DEVELOPMENT FACILITATIVE TEAM (DFT)
HEARING OCTOBER 2, 2024
UPDATE: 06/05/2024 Application Submittal

Project Number PR-2024-010446
SI-2024-00774-SITE PLAN DFT

RE: Site Plan Amendment for new construction

APPLICANT RESPONSES TO THE STAFF COMMENTS:

SHOPS BUILDING
FLOOR PLAN
ELEVATIONS

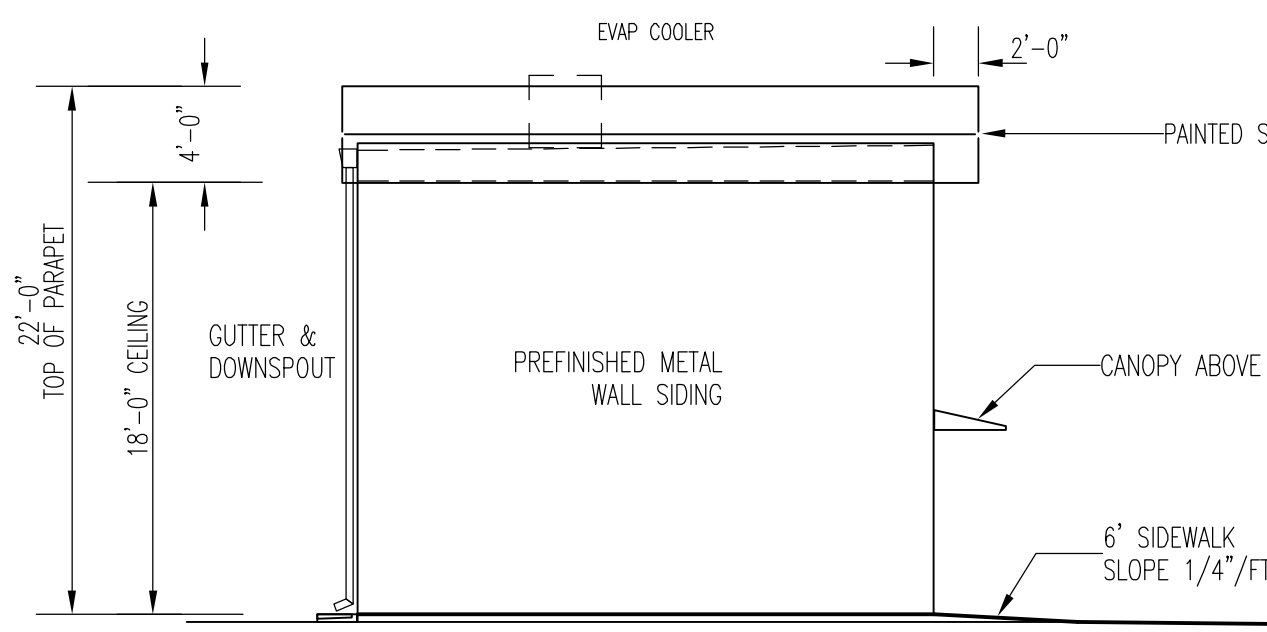
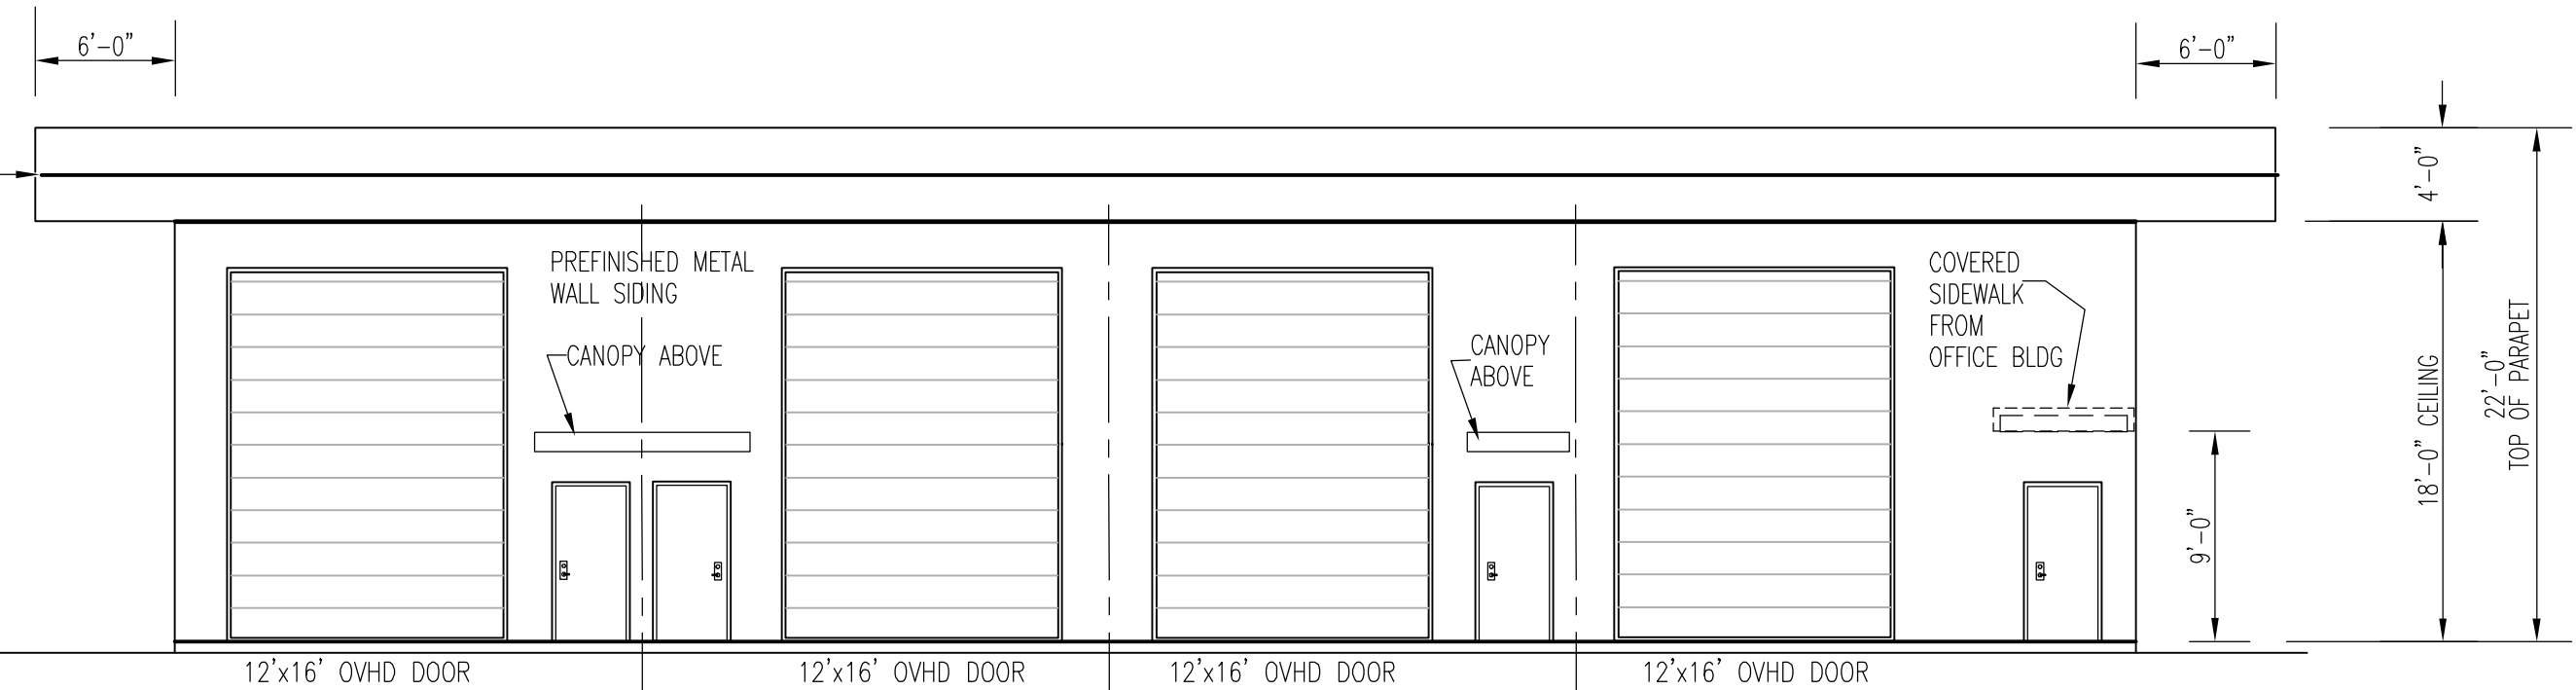
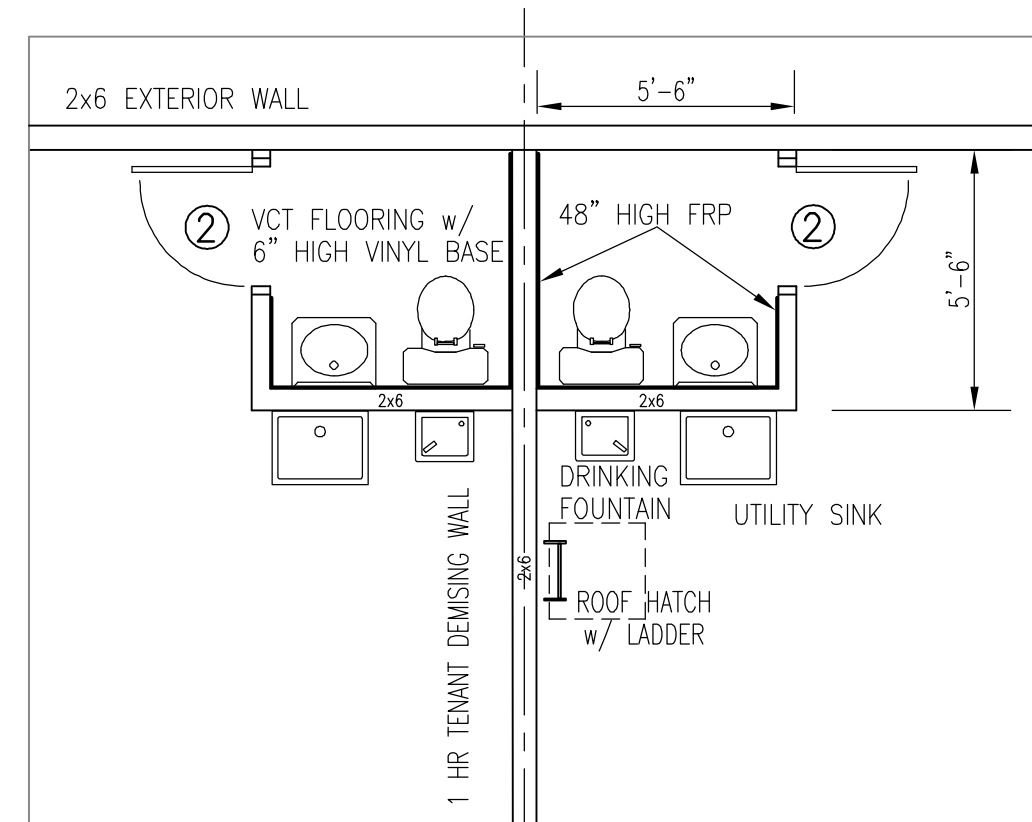
6. Per the Clifford West Master Plan all setback areas must be landscaped. (a.-d.)
7. Provide corrected Parking calculations as per 14-16-5-5-1
- Setback areas must be landscaped and not parking aisle for display parking.
 - Electric Vehicle Parking spaces are required for 5% of the off-street parking spaces (35 EV spaces).
8. Provide elevations including the dimensions, and show how they are meeting the master plan. Include the sides and the materials of the buildings.
9. No further comments at this time.

See the Exterior Building Elevations on Sheets A2 Office Building and Sheet A6 Shops Building.

PERIMETER METAL PANEL FENCE @ SECURE STORAGE AREA

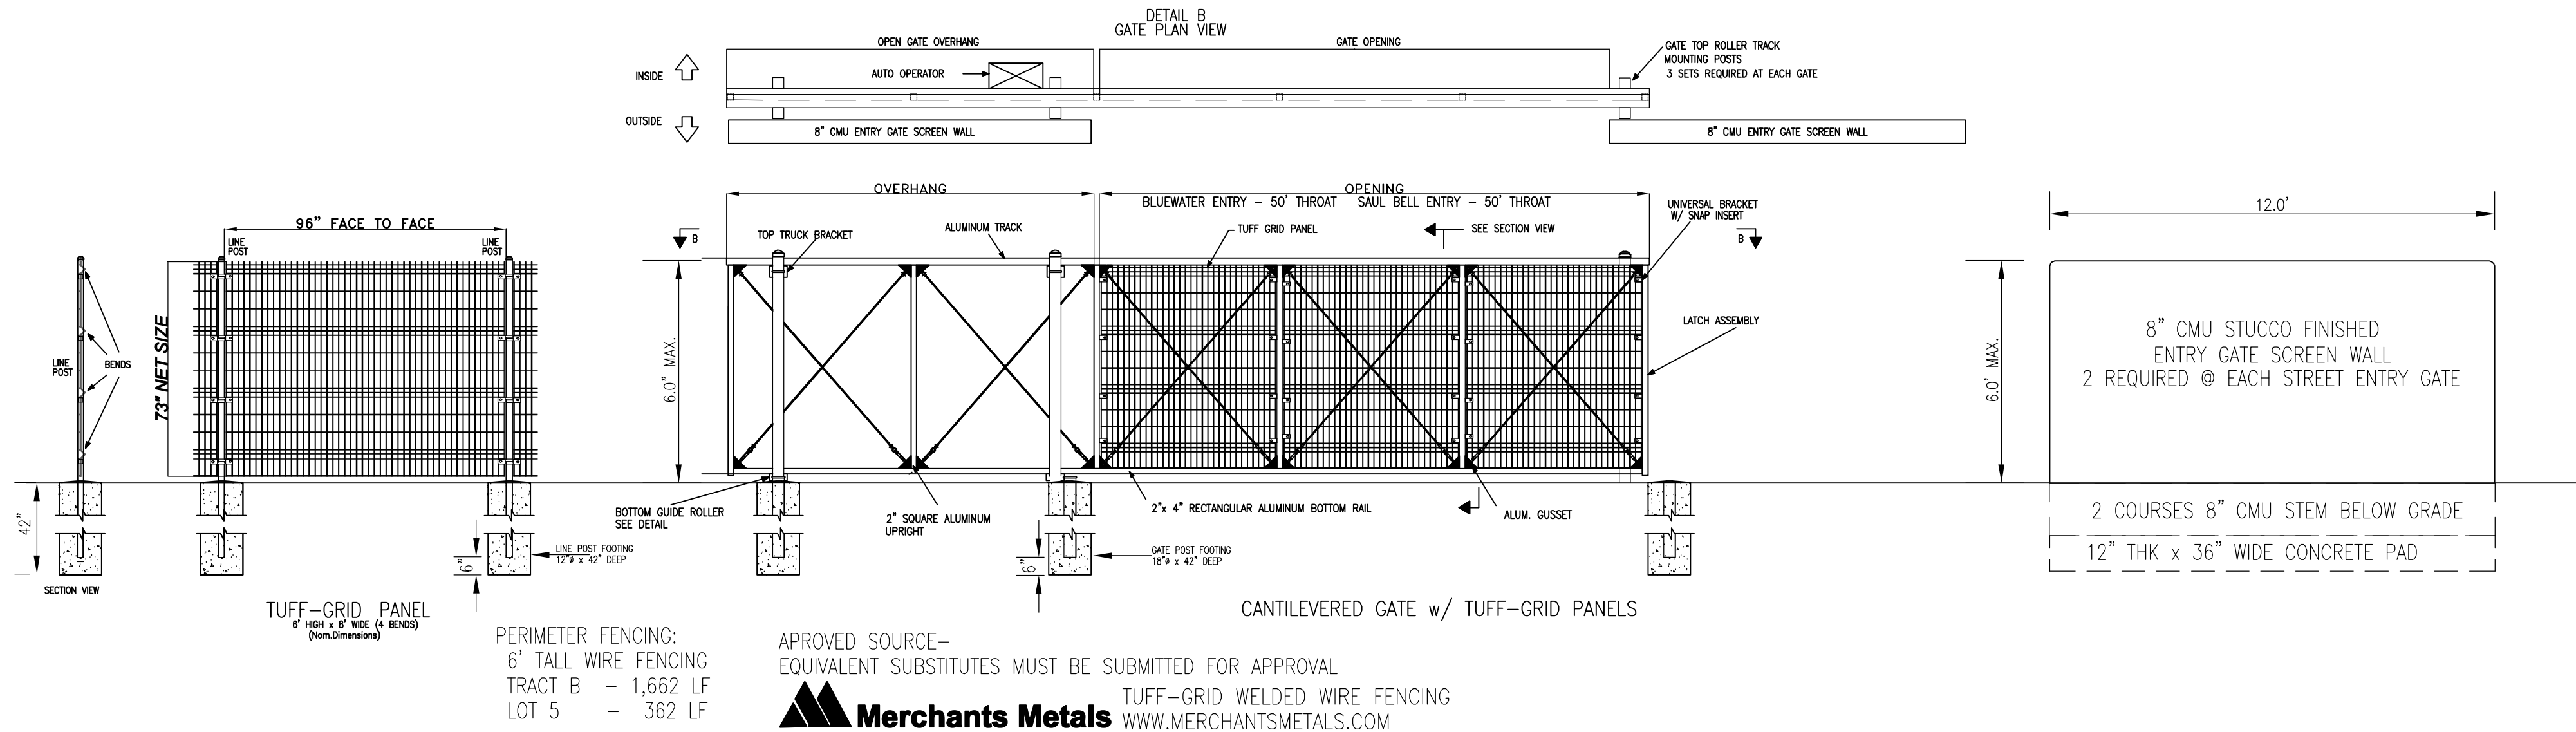
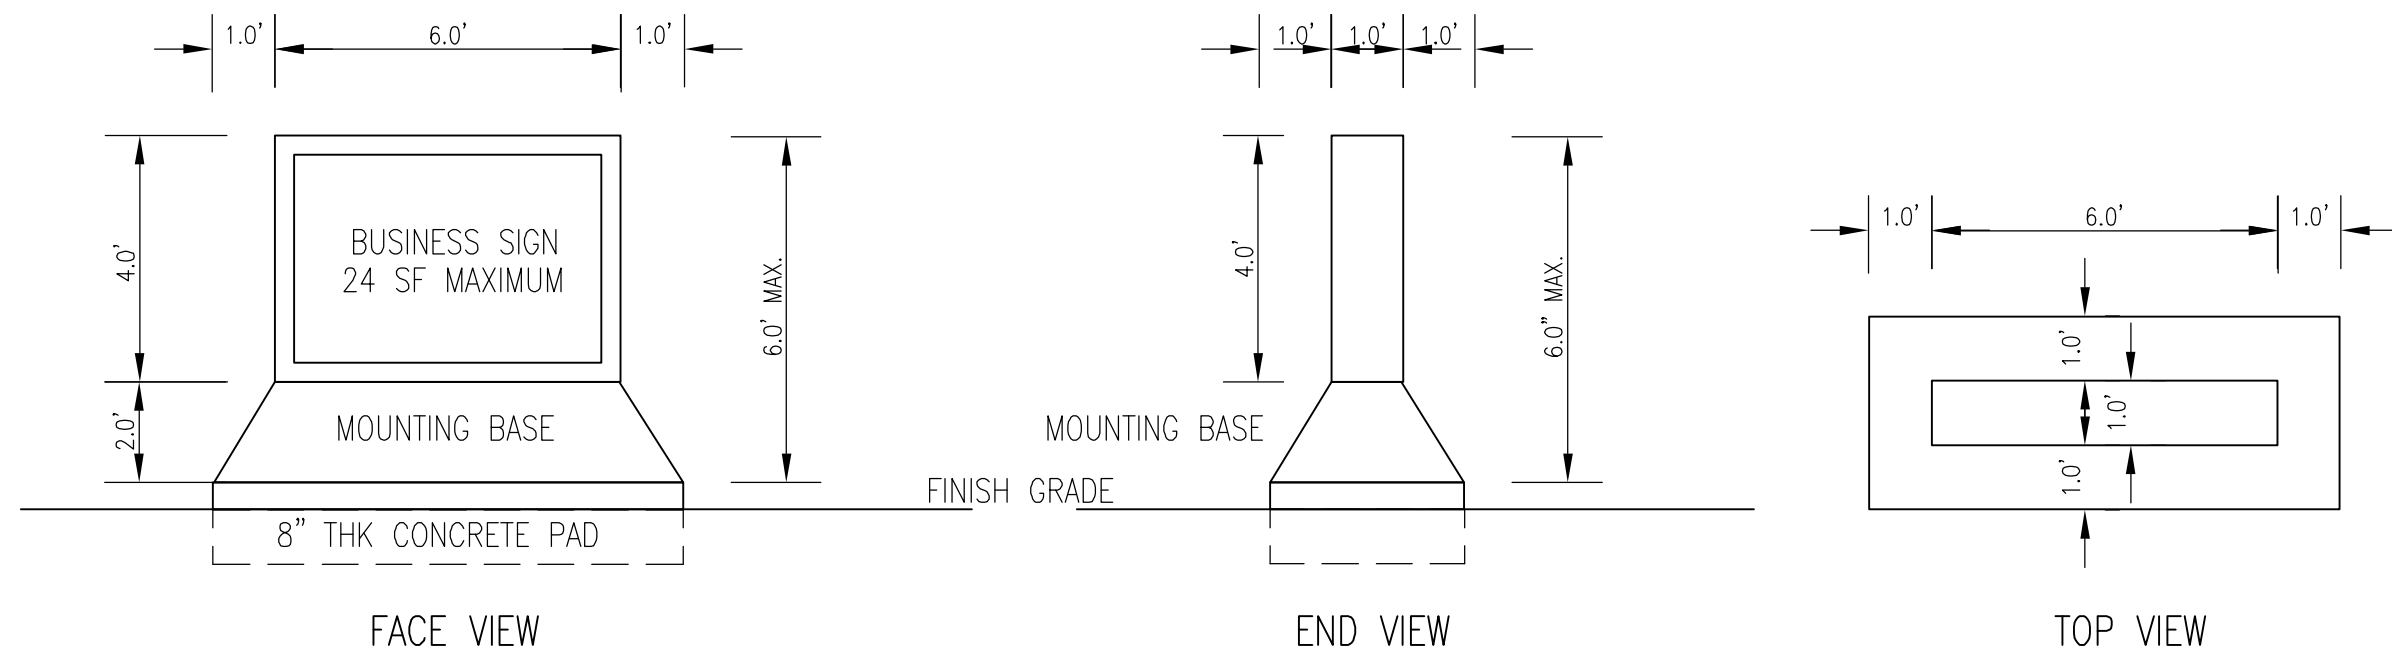
See drawing AC1 Site Plan and new Landscape Plan
- Confirm that the proposed metal fencing is meeting the material requirements of the Clifford West Plan. Walls and fences will require separate permitting through Code Enforcement and/or Building Safety. Wall/fence location and height may require additional approvals, such as a ZHE variance. *Verification per Code Enforcement and section 7 of the IDO.

See Drawing AC-2 for details. All fencing is specified to be 6' in height complying with general development regulations. Open fencing is located on the street frontage. Opaque steel panel fencing 6' high will be installed on the perimeter of the Shop Building vehicle storage area.
- Clarify compliance with the Clifford West Plan and section 7 of the DPM Table 7.2.29 regarding Sidewalk width requirements, the landscape buffer, and trails along Bluewater and Unser.

1 ELECTRICAL SITE PLAN

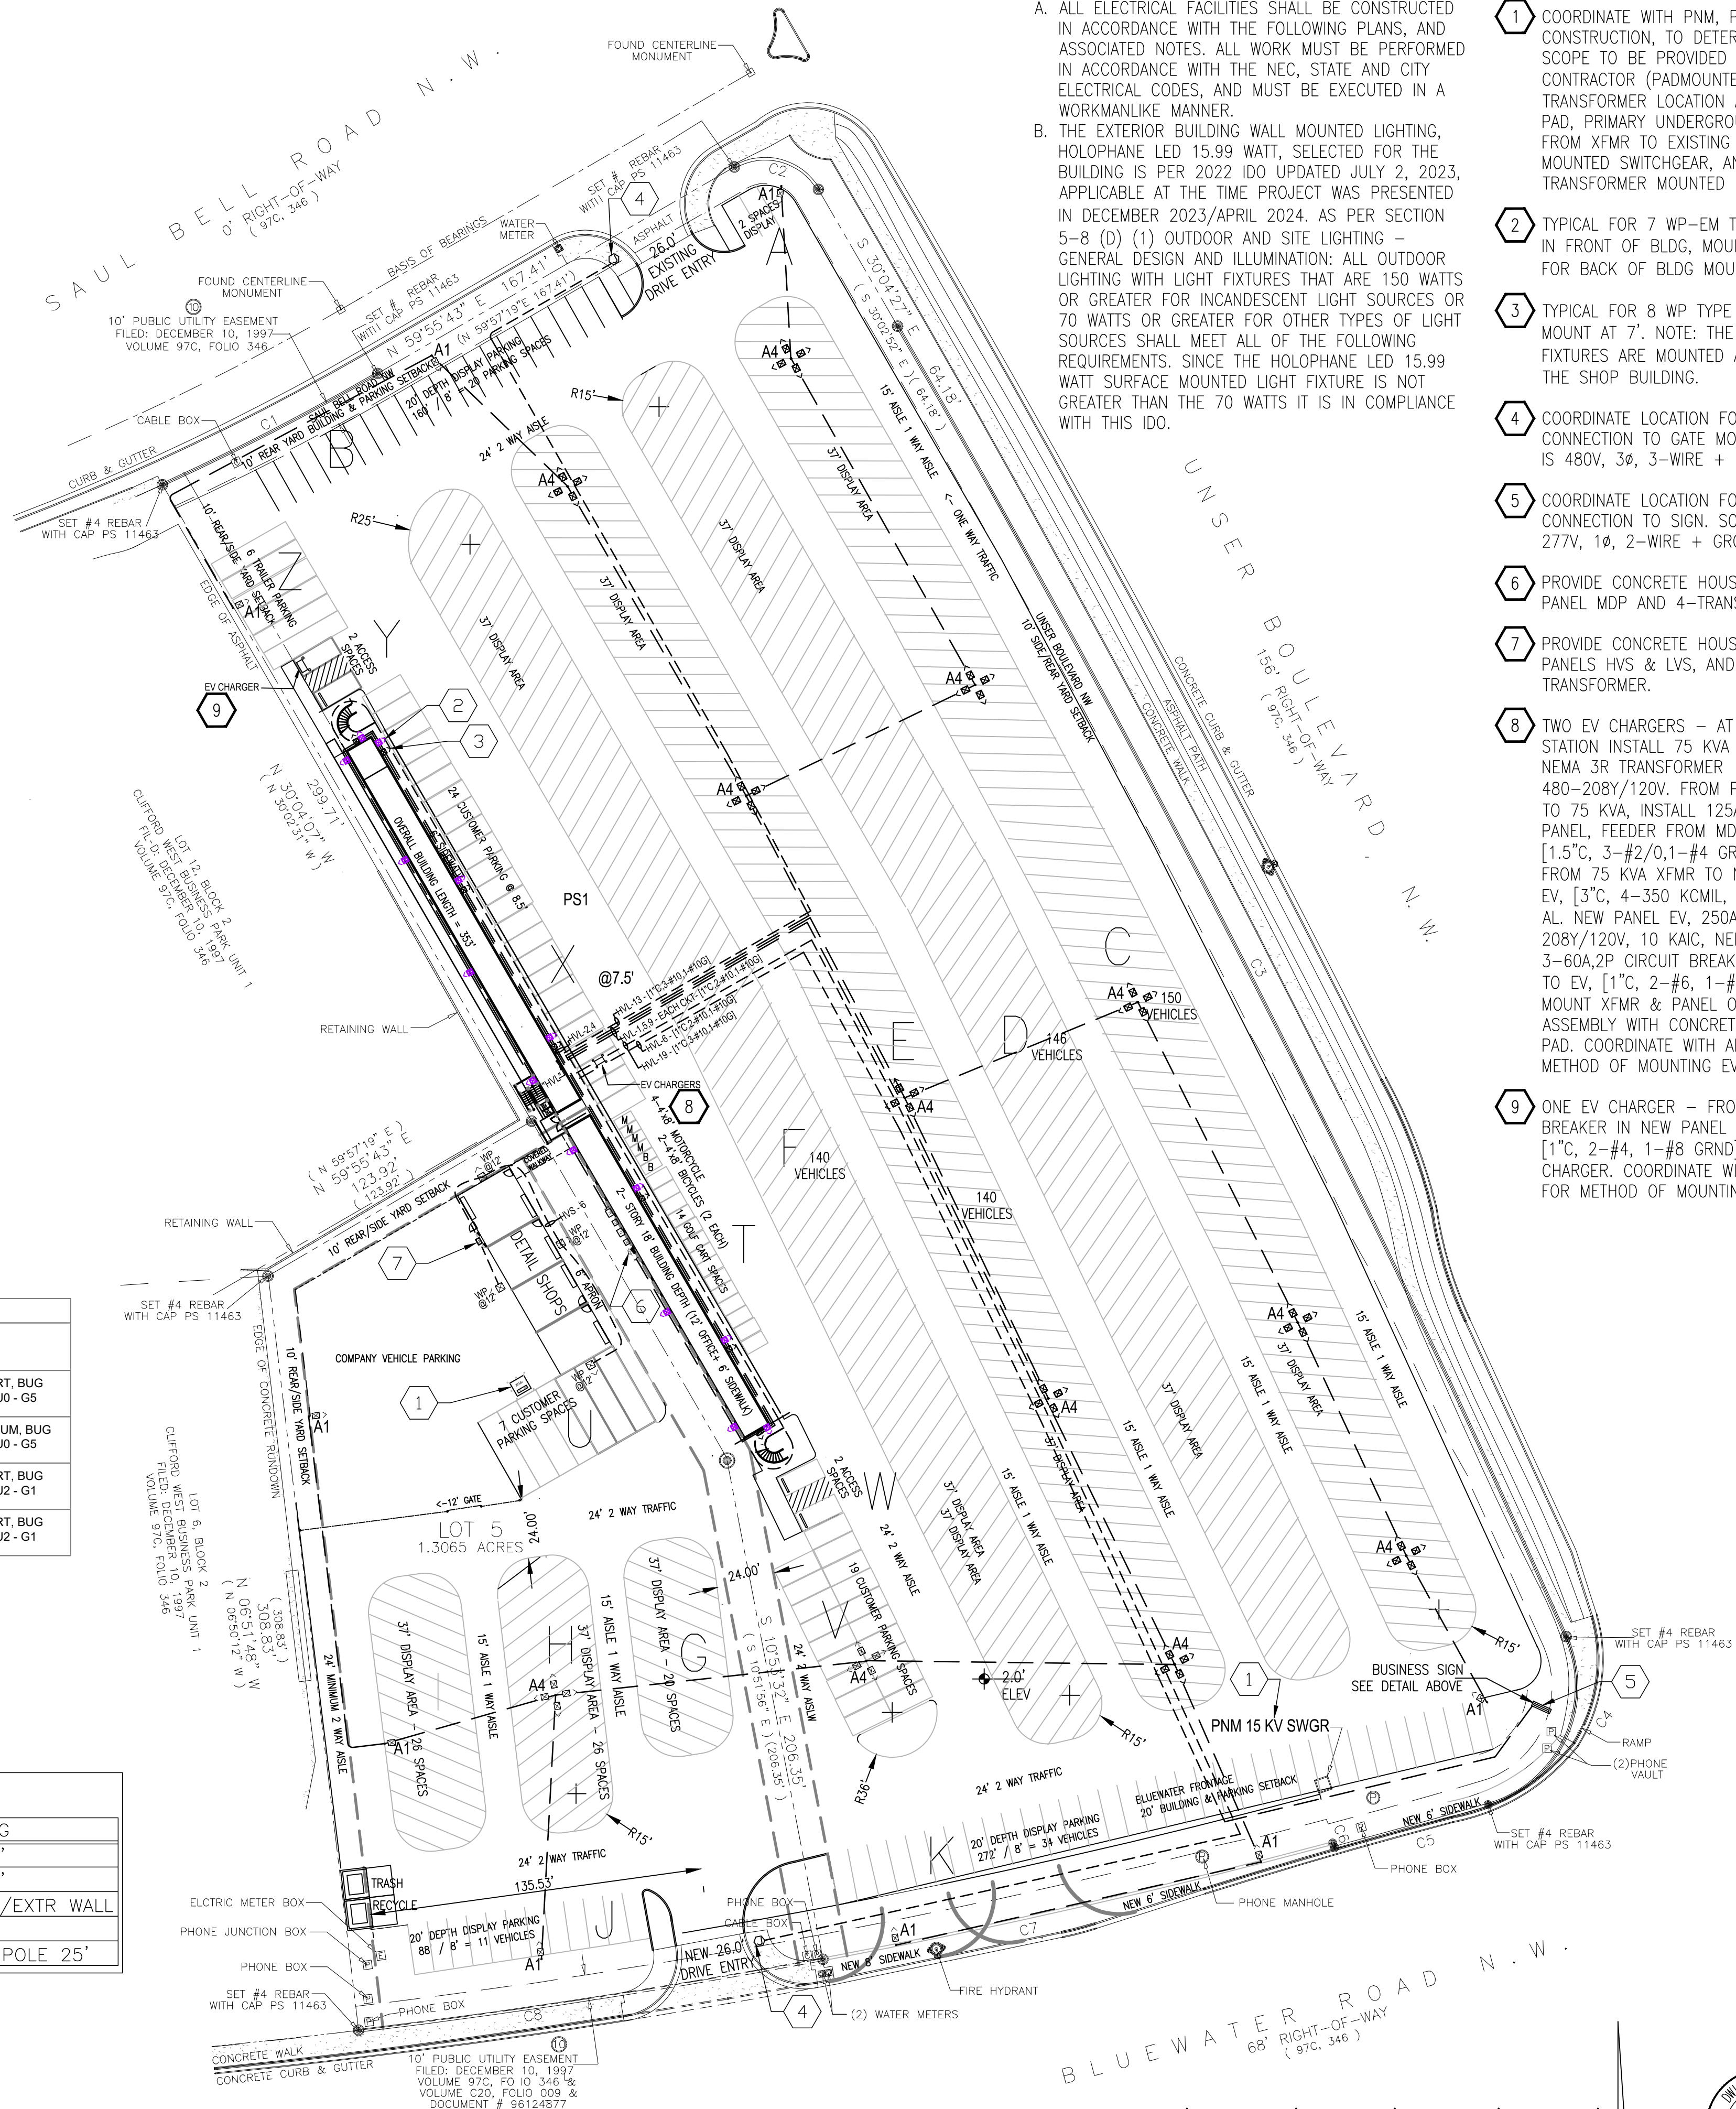
3. Provide the height of the parking lot light poles. Light poles are limited to 25 feet per master plan.

Poles are specified as 25' height as shown on Sheet E1 Electrical Site Plan.
